Laurie Leader - Re: BP#2014-02753 107 Walton Street - Plan review comments

From: Joshua Biermann <joshuabiermann@gmail.com>
To: Laurie Leader <LRL@portlandmaine.gov>
Date: 1/14/2015 1:03 PM
Subject: Re: BP#2014-02753 107 Walton Street - Plan review comments
Attachments: Ledger Detail.jpg; Post and Beam Detail.jpg; Walton Deck M1 plot.jpg

107 Walton St. Deck Rebuild

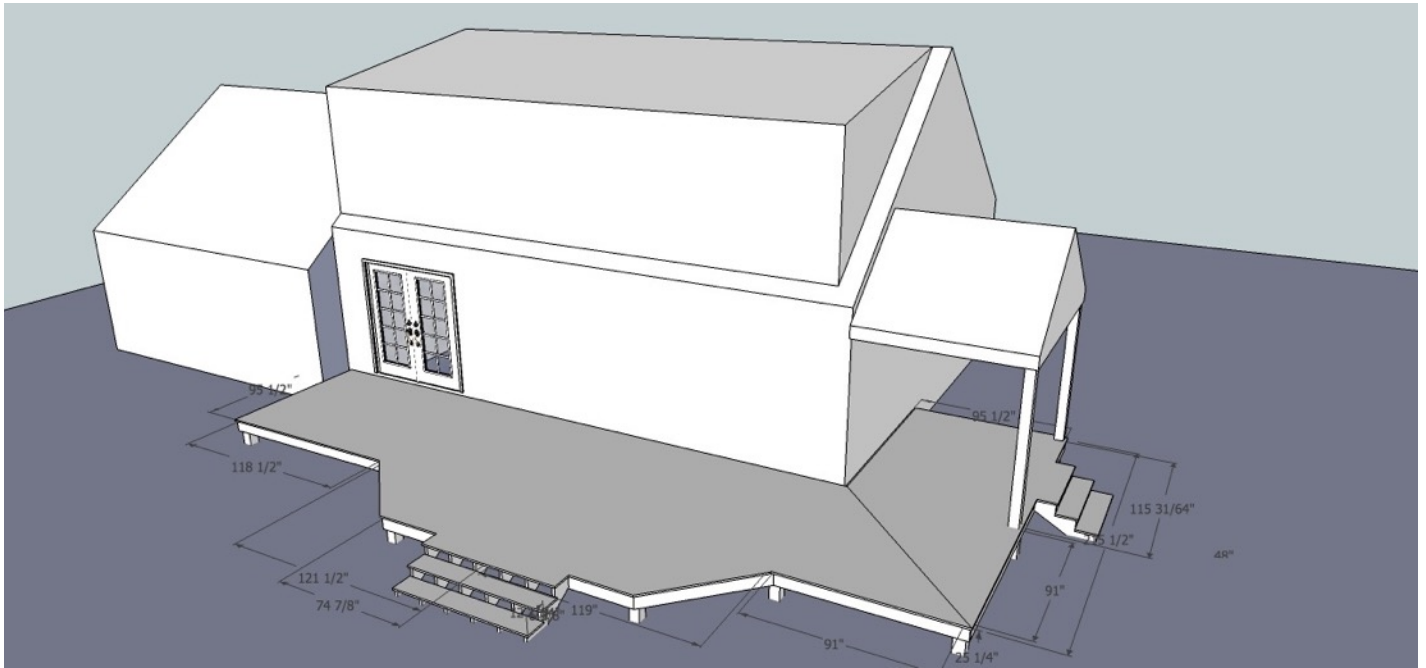
I have completed the review of the above project for building code and have the following comments as noted on the attached files.

Just to clear things up, yes, posts are 6 in. by 6 in. but 6 foot by 6 foot, type in the plans. Secondly, the only remaining structure from the original side porch will be the roof structure, the porch itself had rotting framing structure and as such will be completely rebuilt. Please see attached images for ledger detail, post/beam detail and plot offset (180' from porch to rear of property and 20' from porch to side of property).
